Technical Note: Planning Review of Oldlands Farm, Bognor Regis

Project: 3213 – Oldlands Farm, Bognor Regis

Date: 27 July 2021

Revision: Rev1

## Drawing 1 – Flood Compensation Area, Proposed Area

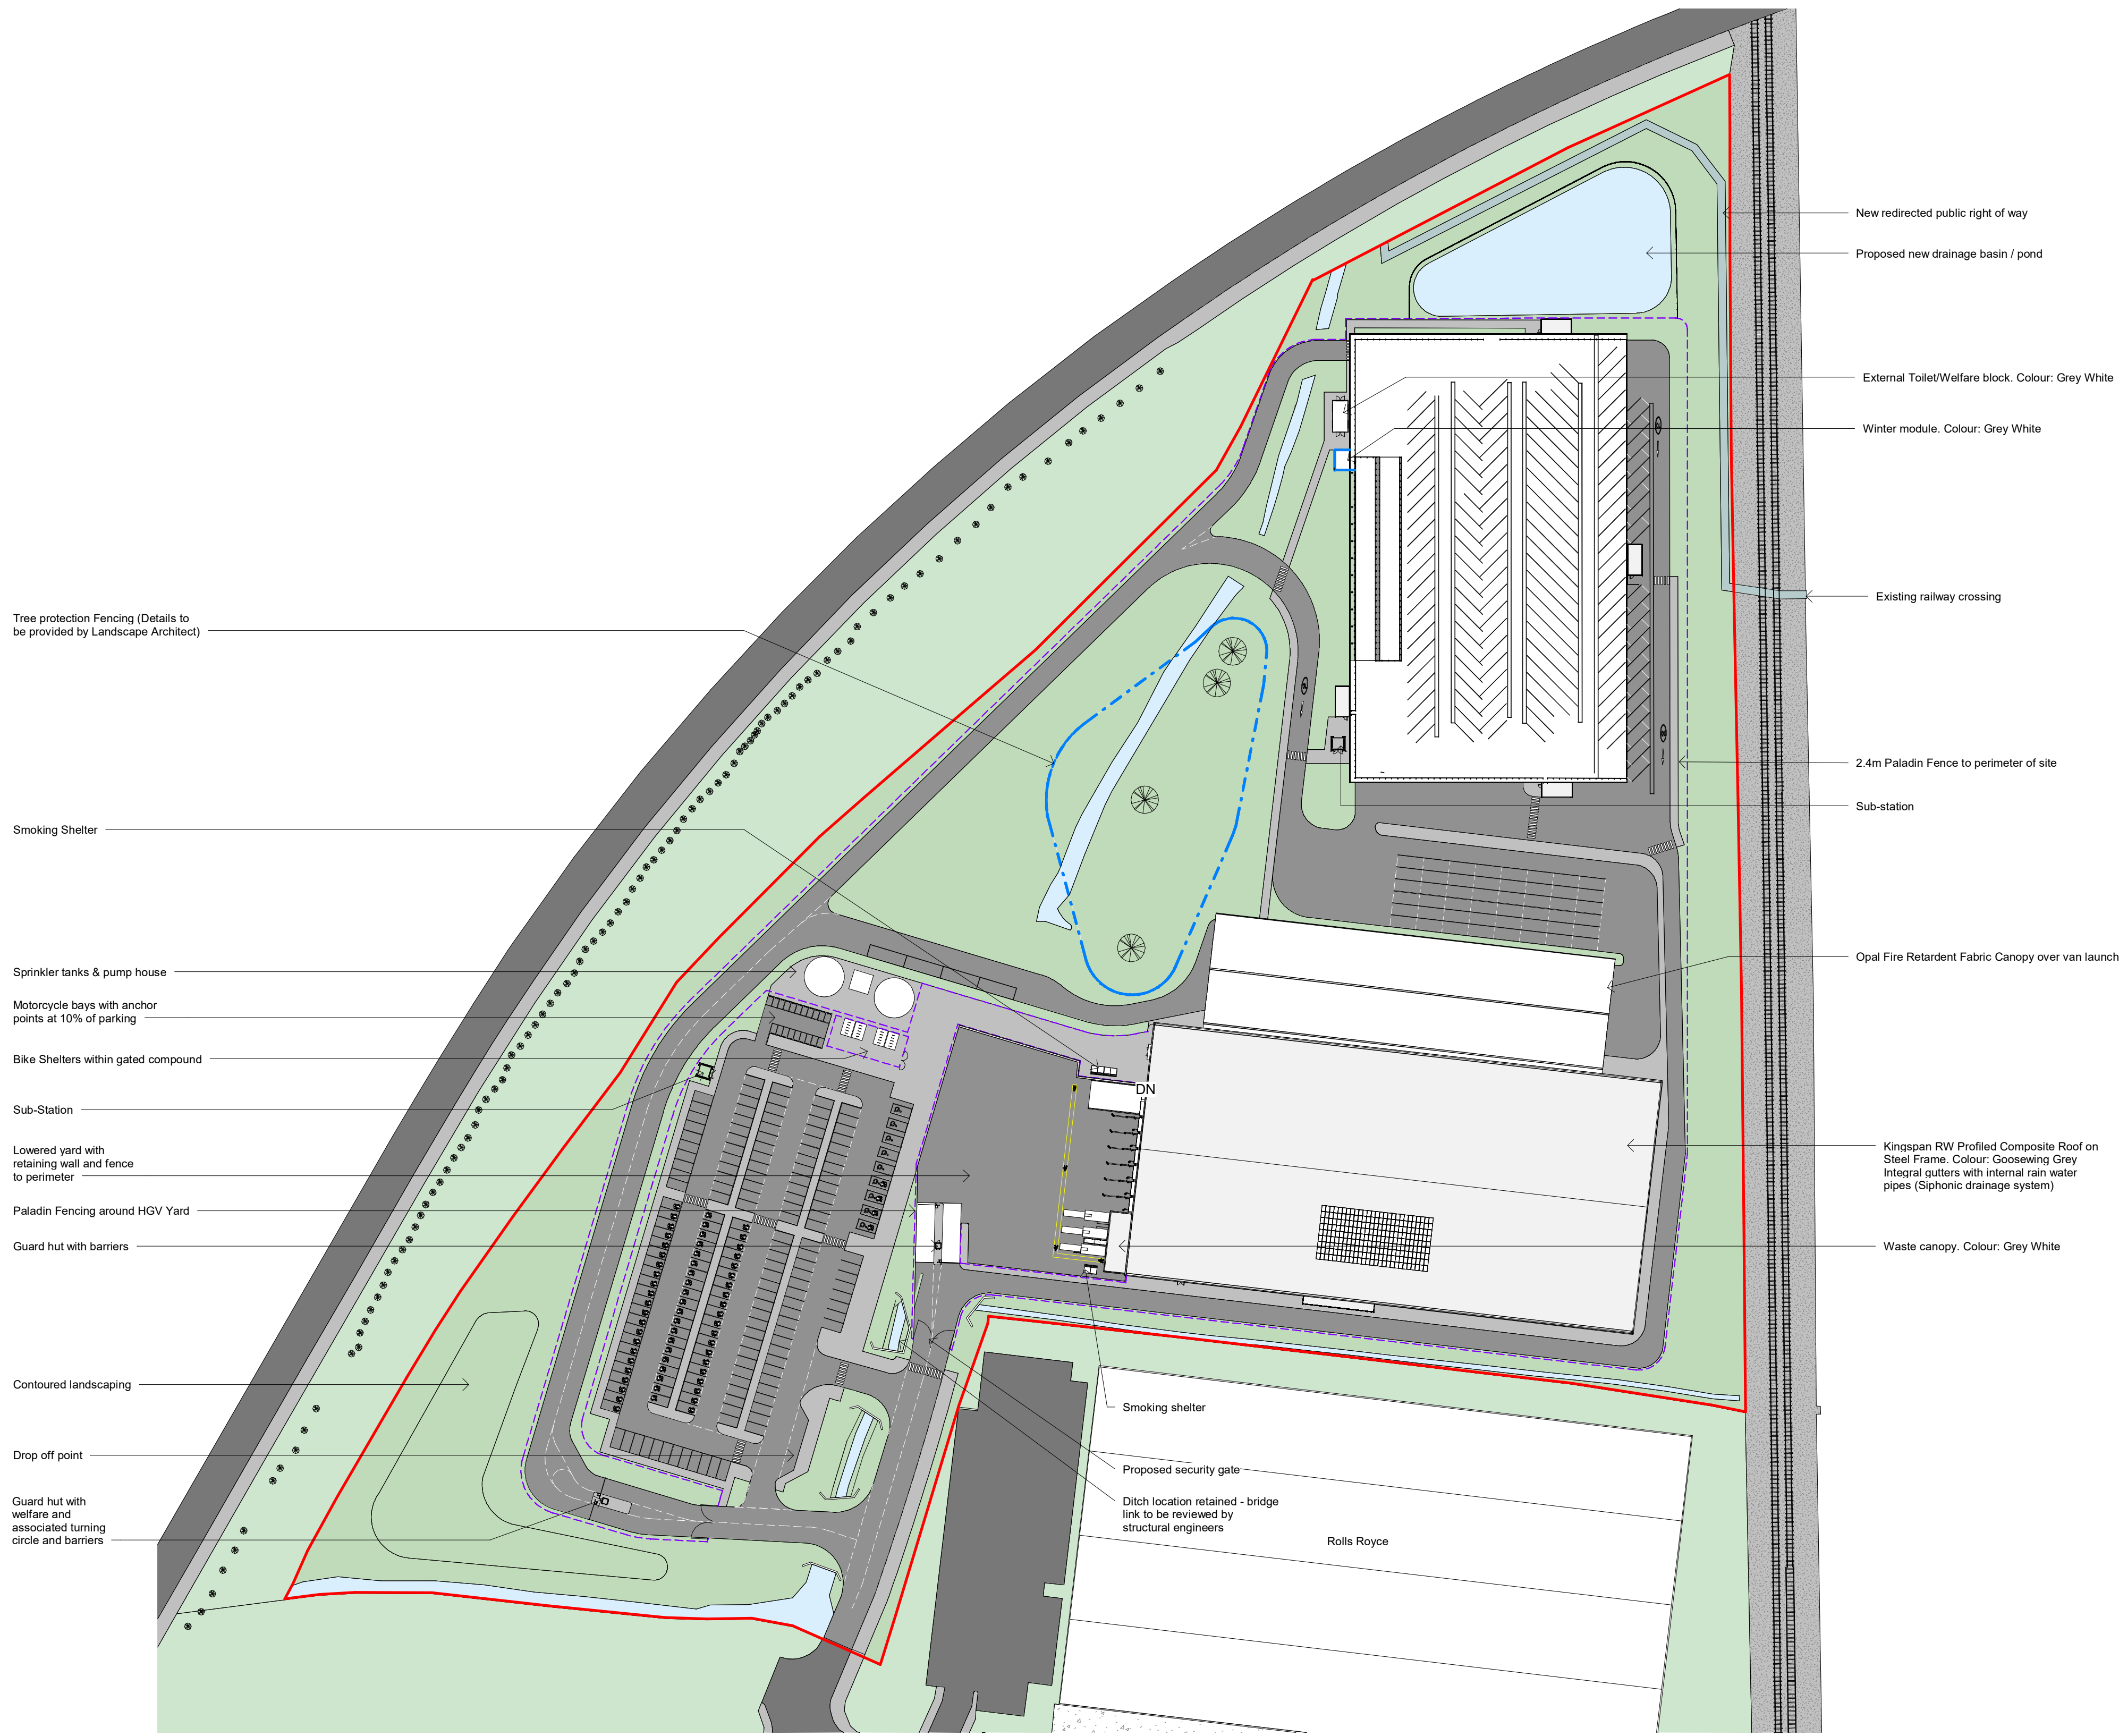
- 3.9. With respect to the Flood Compensation Scheme (FCS), it is evident that the values are based on a level per level, volume by volume basis. Whilst it is recognised that it is the EA’s responsibility to comment on the suitability of this system, we would expect to see further details provided, i.e. in the form of a hydrodynamic flood model, used to assess the pre- and post-development flood mitigation measures. This is recommended given the uncertainty regarding the hydraulic connectivity between all parts of the site and the FCS, (which are partially separated by the existing and proposed roads – linked by culverts in places beneath the service road). Any future hydrodynamic flood modelling should include the appropriate allowance for climate change.

- 3.10. Additional details of the flood storage area would be required to confirm that flows (in and out of the storage area) are comparable to the existing predeveloped situation and to confirm that infilling the ditches and rerouting the watercourse will not have a negative impact offsite. This is particularly important due to the position of the storage area, at distance from the source of flooding. The ecological impact of infilling these ditches should also be considered and evidence should be provided by the Applicant to demonstrate that any impact is acceptable.
